Subject: FW: LU/274/21/DOC - 2 Croft Cottages, Pier Road, Littlehampton, BN17 5LS

In reference to the above application to discharge condition 12 of LU/159/19/PL at the above site and having reviewed RF Environmental's Noise Impact Assessment (ref.: RFE-0360-21-02, dated July 2021), EH is satisfied that the condition can be discharged, based on the following points:

From: Kate Giddings <kate.giddings@arun.gov.uk>
Sent: 04 October 2021 17:05
To: Amy Myer <Amy.Myer@arun.gov.uk>
Cc: Planning.Responses <Planning.Responses@arun.gov.uk>
Subject: LU/274/21/DOC - 2 Croft Cottages, Pier Road, Littlehampton, BN17 5LS

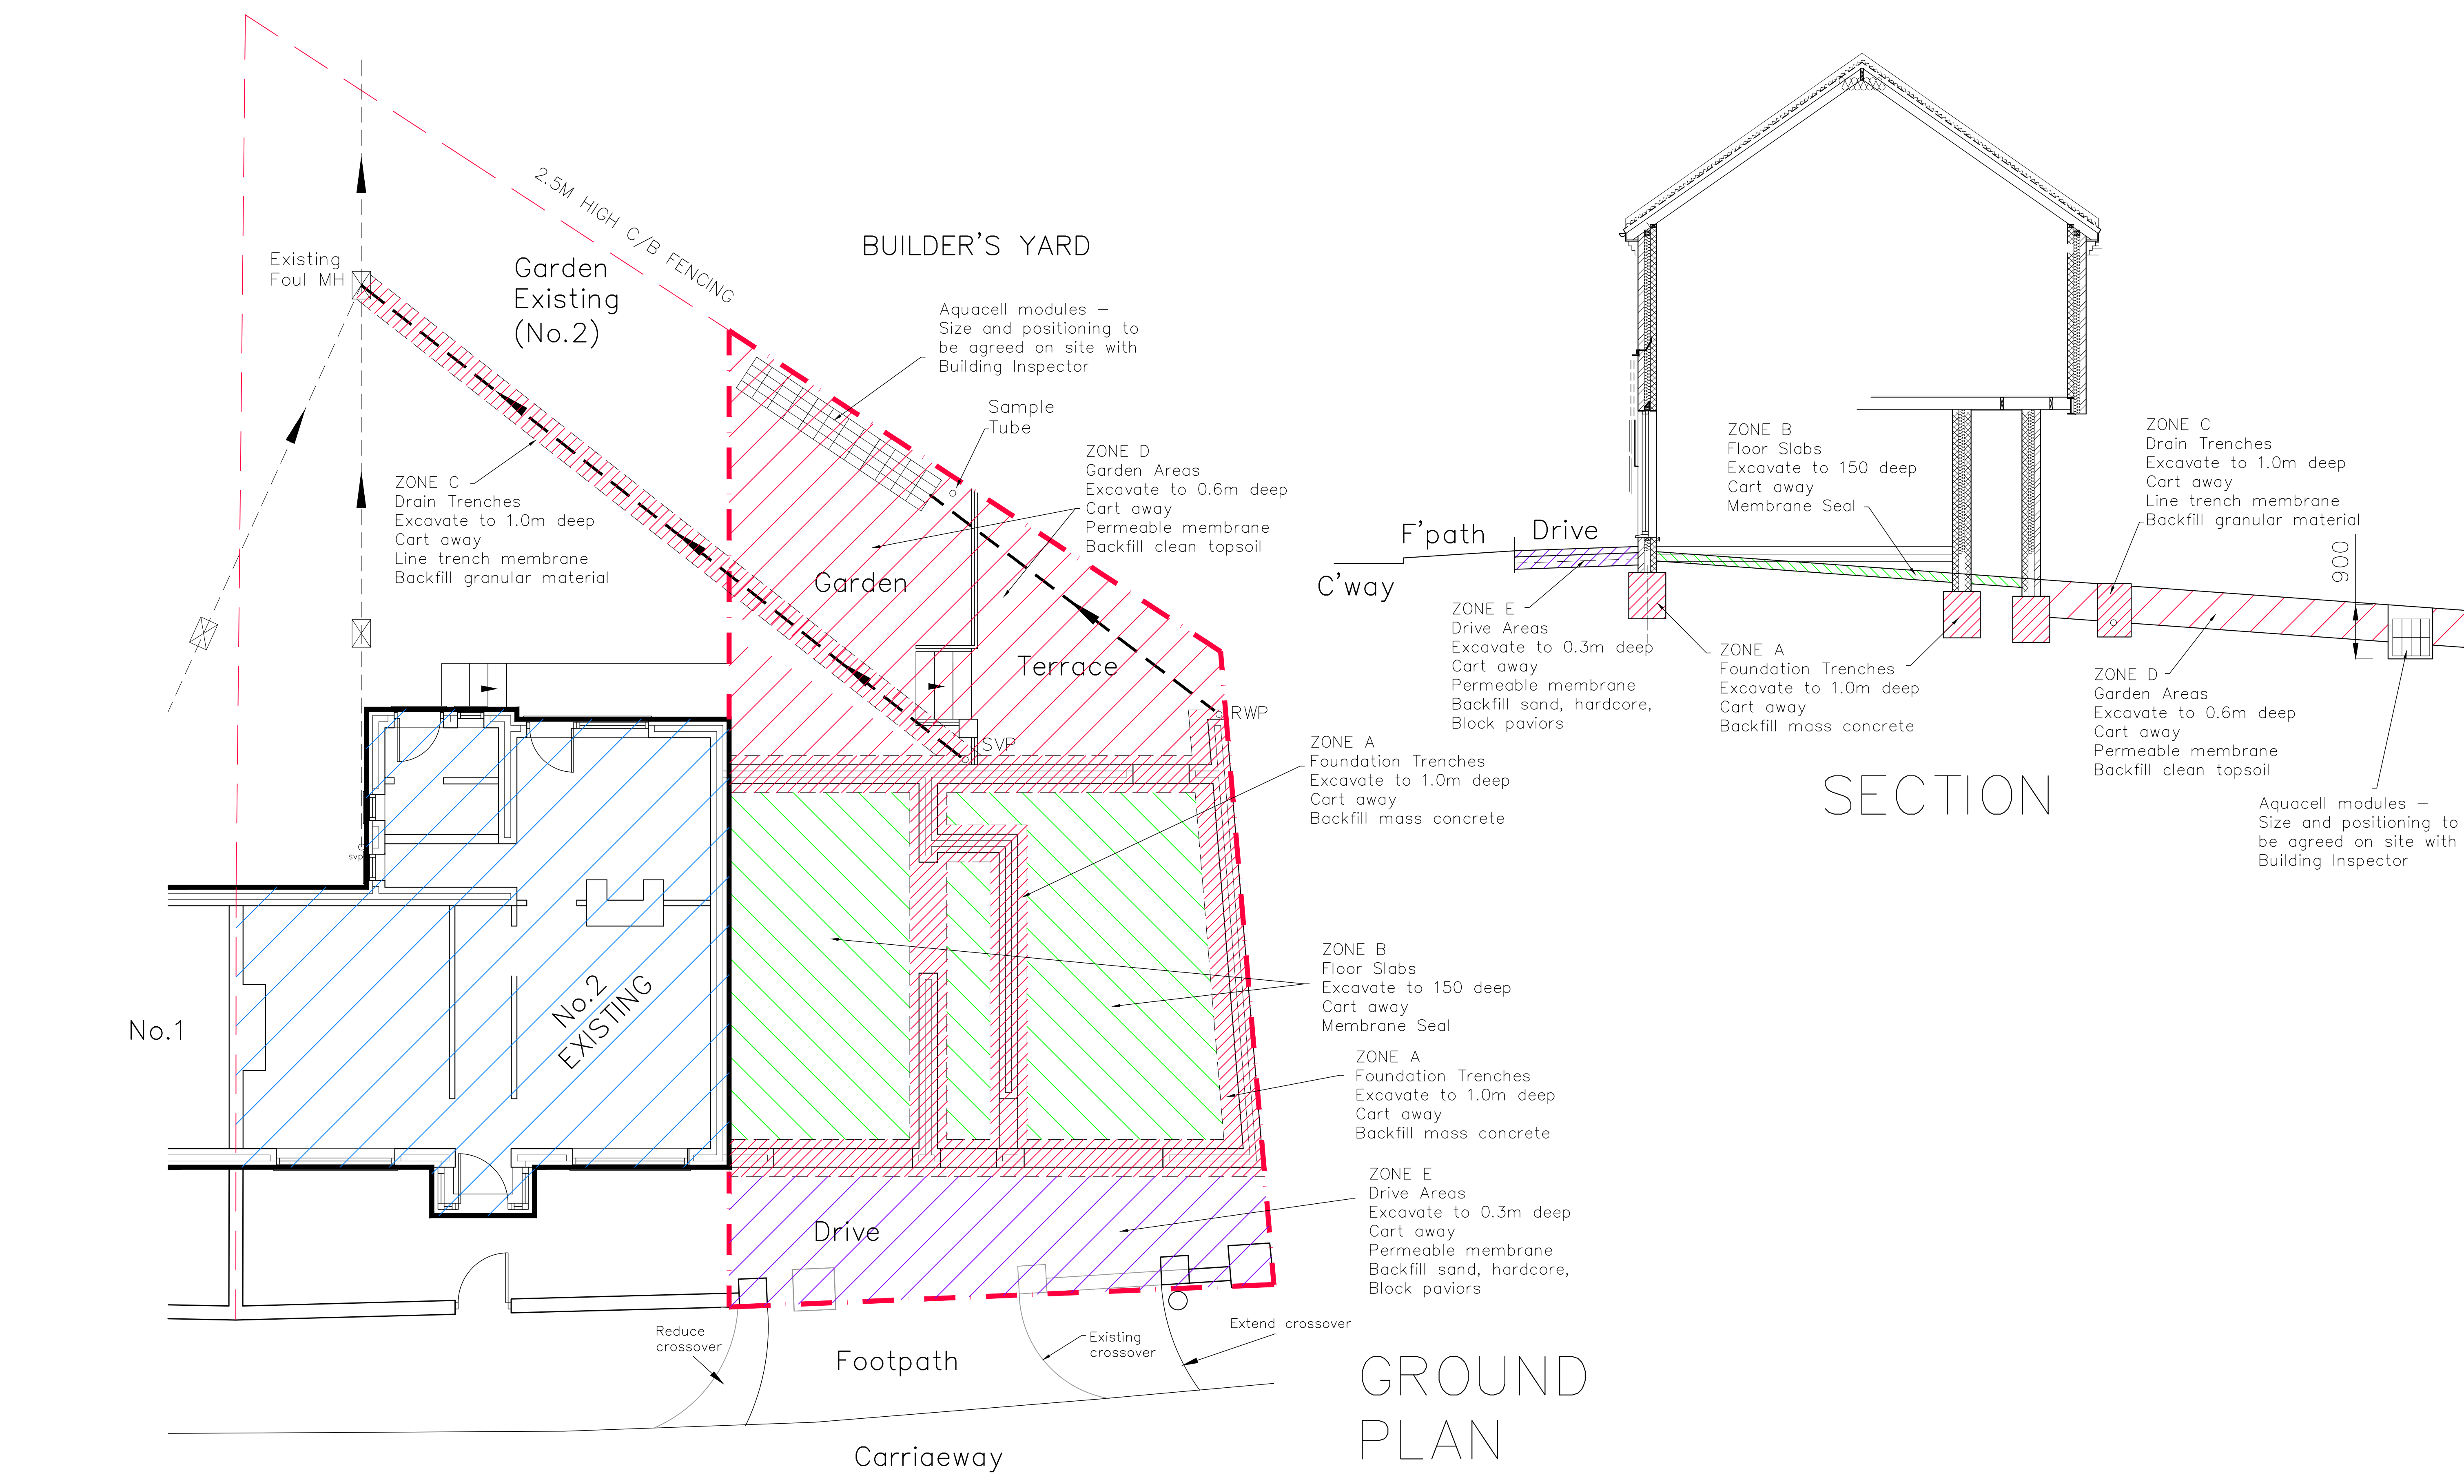
Notwithstanding the above request for information, it is unclear whether the Aquacell modules as depicted on Critchley Architecture and Design Ltd.'s Proposed Contamination Containment plan (rev. A, dated August 2021) are soakaways – please may this be clarified as this may contradict the Environment Agency's recommendations of not installing such structures in made ground/contaminated land.
